To: Jack Cloud, Chair Development Review Board

From: Vicente M. Quevedo, Planner

RE: Project 1002848, 14EPC-40043, 14EPC-40046

SITE PLAN
A100

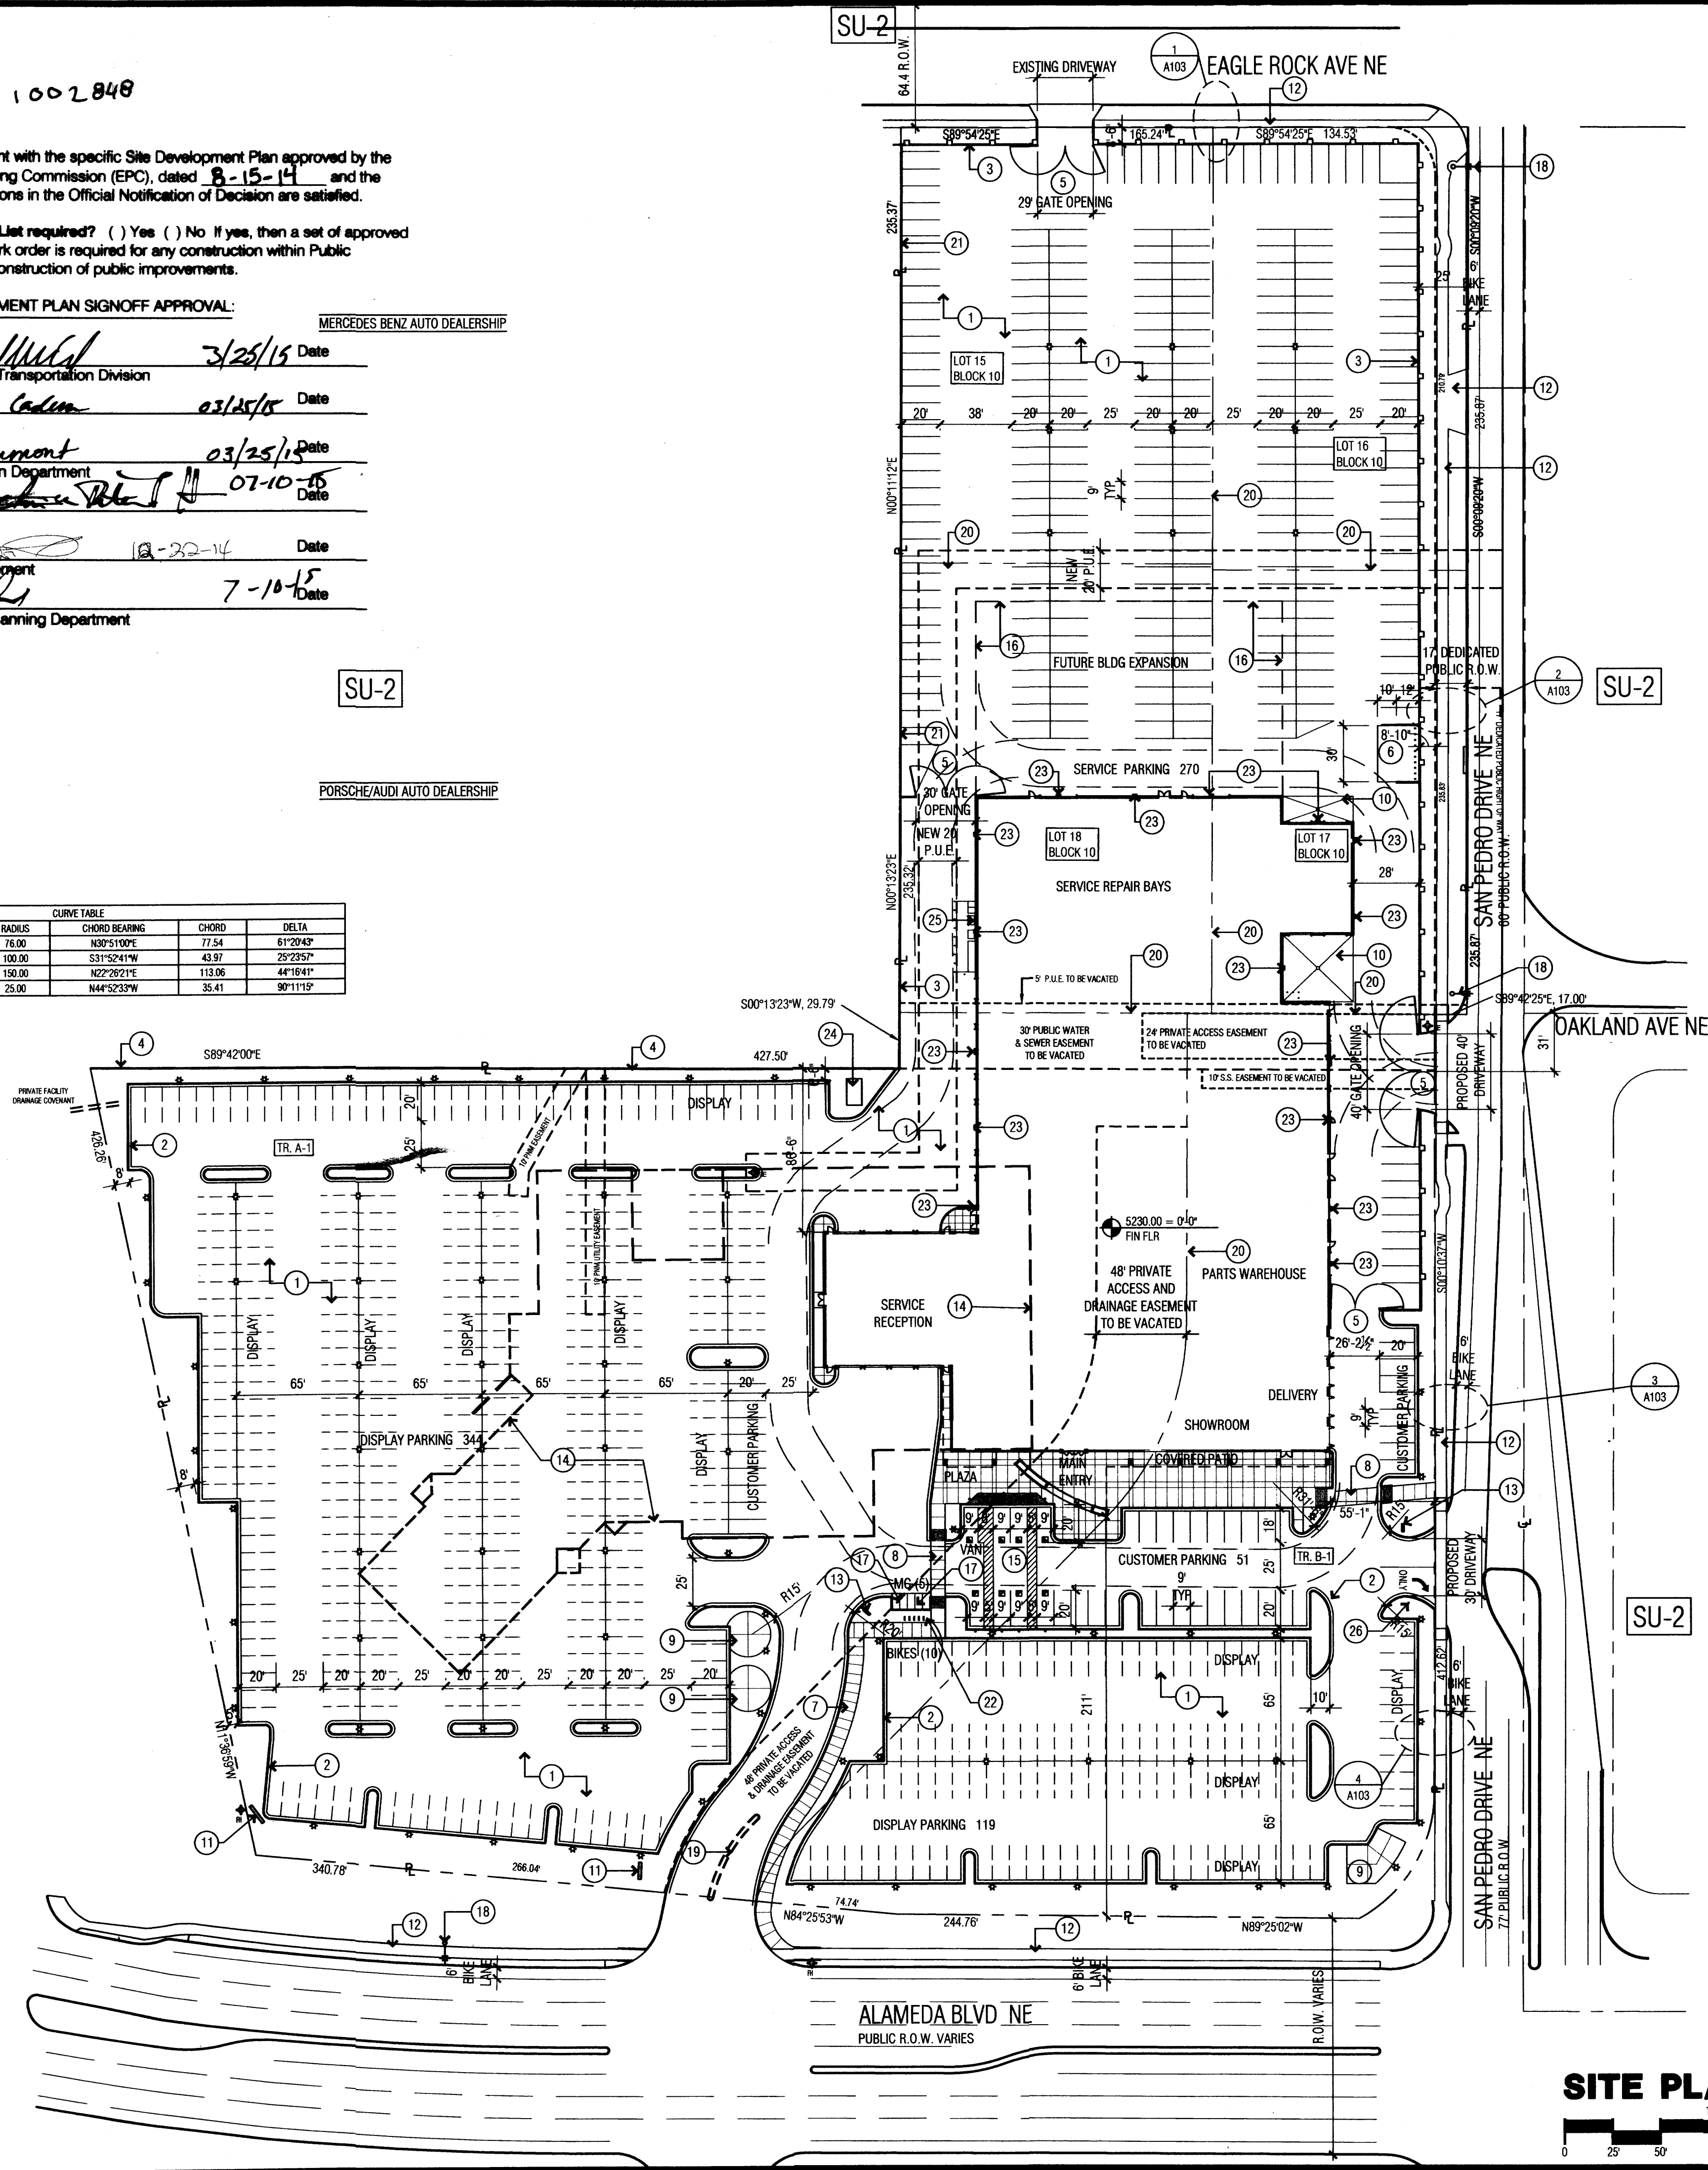
Staff Comments: The applicant has updated the site development plan to reflect the dedication of the 17' public roadway easement as public right-of-way. However, no on-street bike lanes with dimensions per the DPM are outlined on the updated site development plan as required by the condition of approval.

Staff Comments: The applicant has updated keynote 3 on the site development plan on sheet A100. However, keynote 3 on site details sheet A101 still reads 6" HIGH CMU WALL.

2 GATE ELEVATION

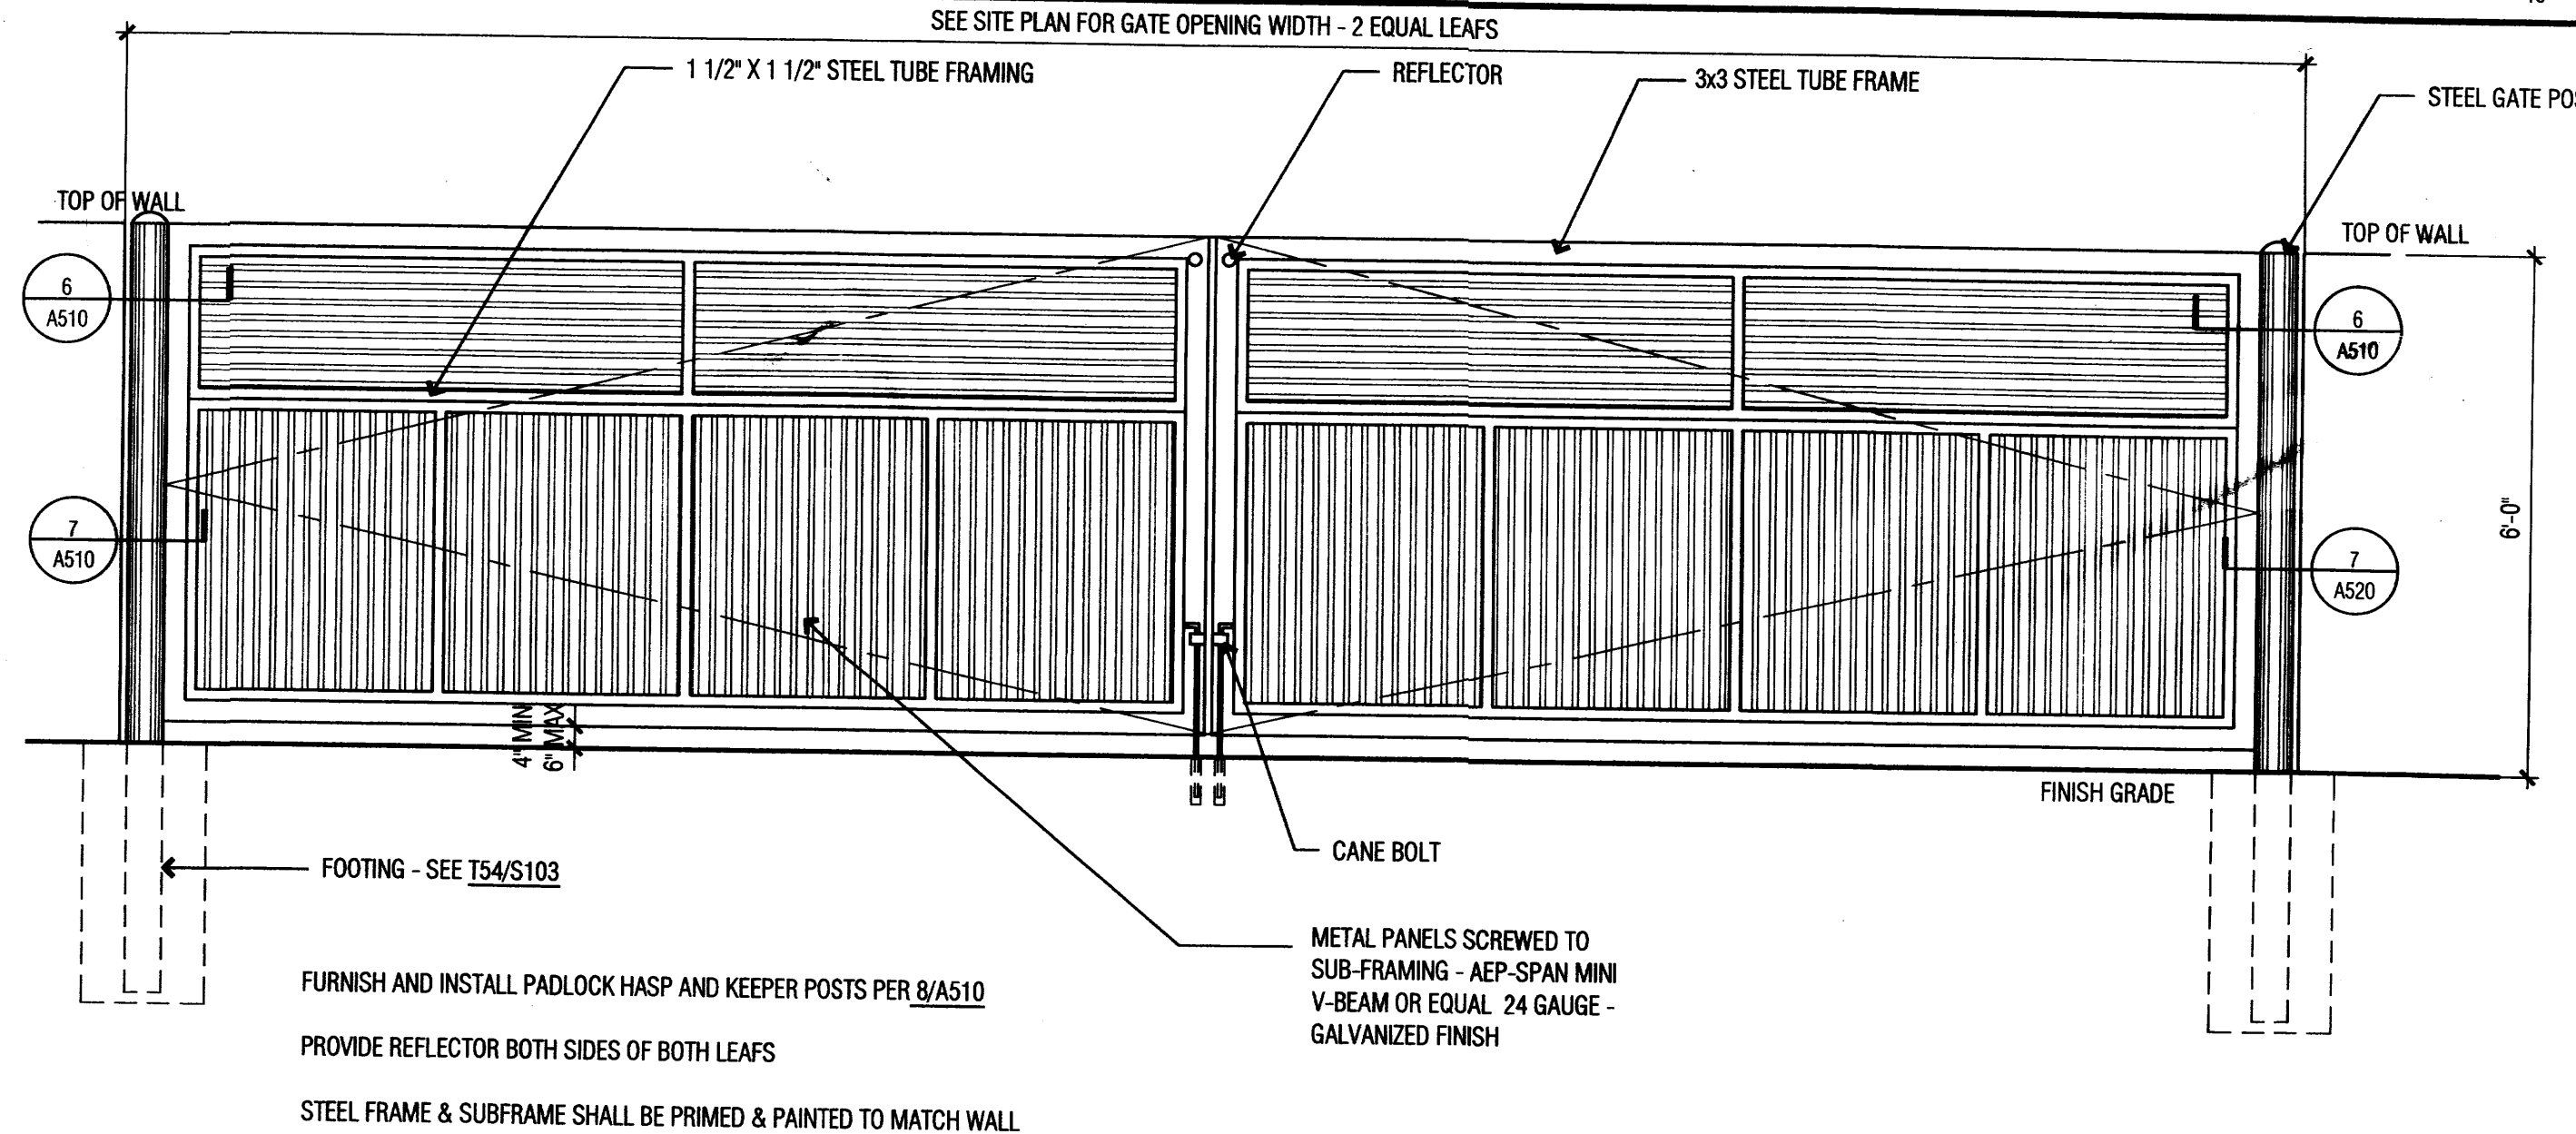
14. Note 3 on the site plan and sheet 7 of 7 A101 Keynotes section shall be revised to read "6' High CMU Wall...", as they now incorrectly reads "6 inch High CMU Wall".

**A100**

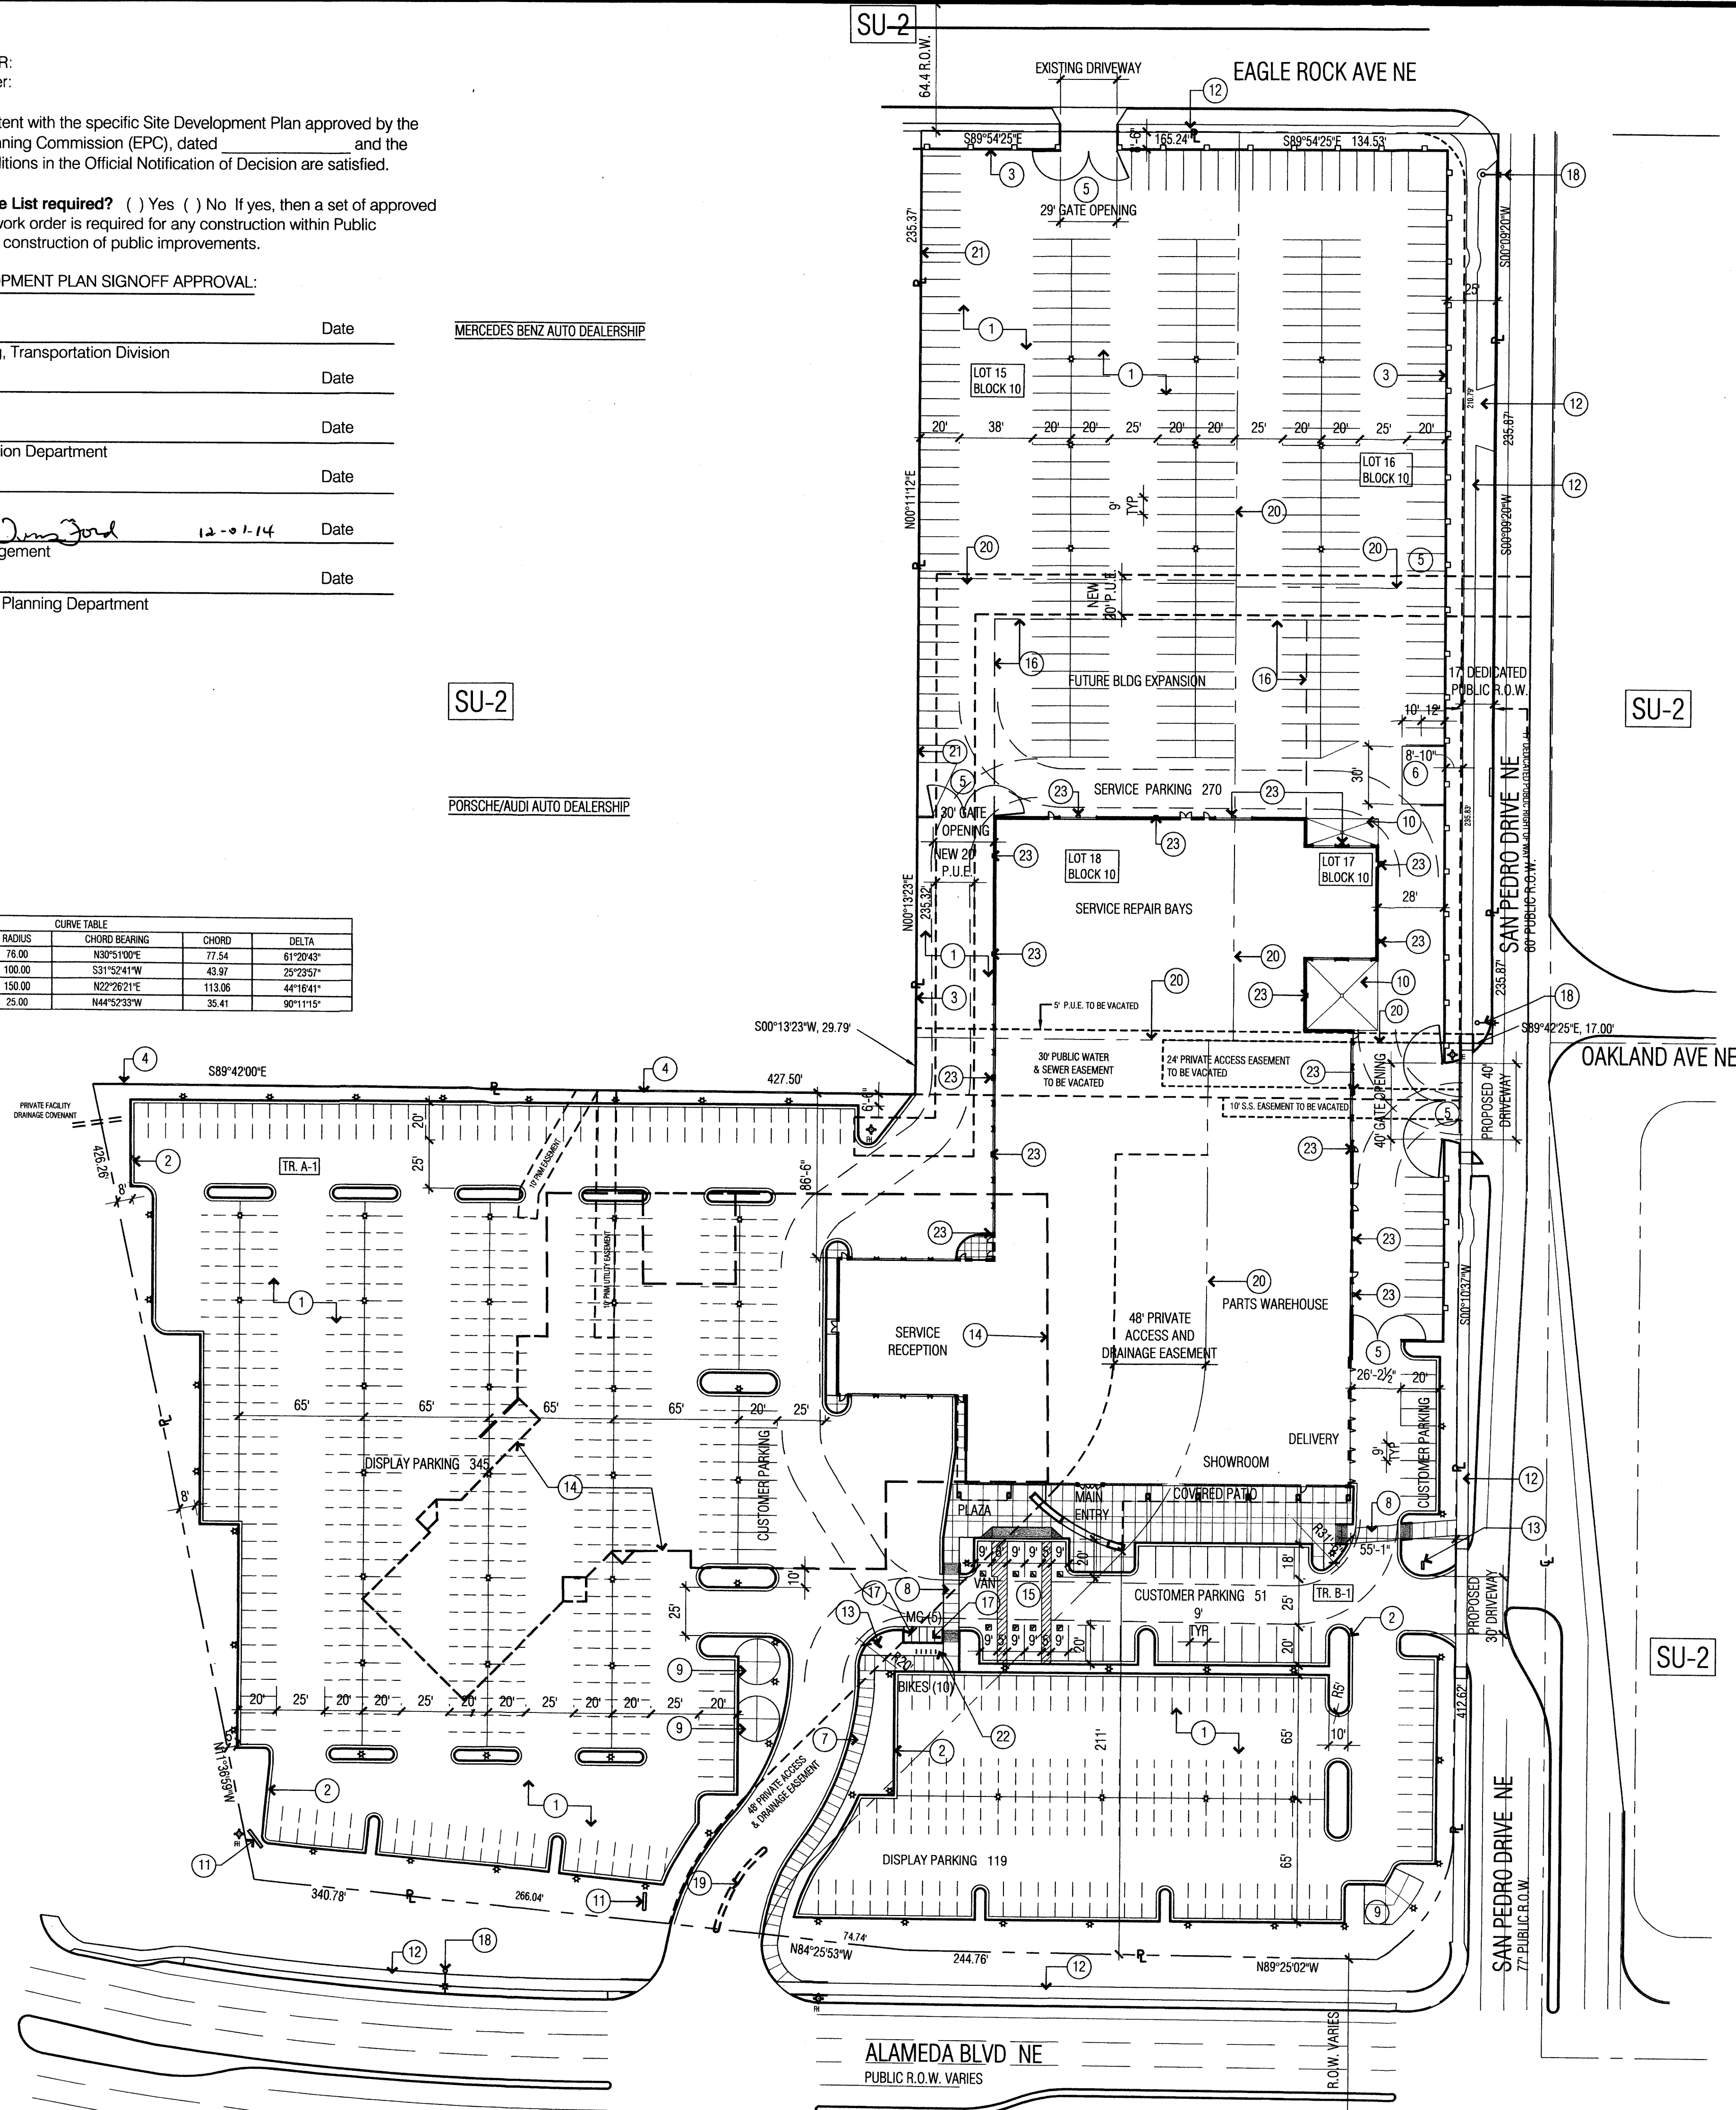
- a. Per the Long Range Roadway System map Alameda Blvd. is listed as a Principal Arterial and San Pedro a Collector. Along San Pedro the existing and proposed right-of-way lines are not well identified on the site development plan. The 17' public roadway easement called-out along San Pedro needs to instead be dedicated as public right-of-way. Per the Long Range Bikeway Systems map both Alameda and San Pedro are to contain striped on-street bike lanes with dimensions per the DPM, if they don't already exist along the site frontage.
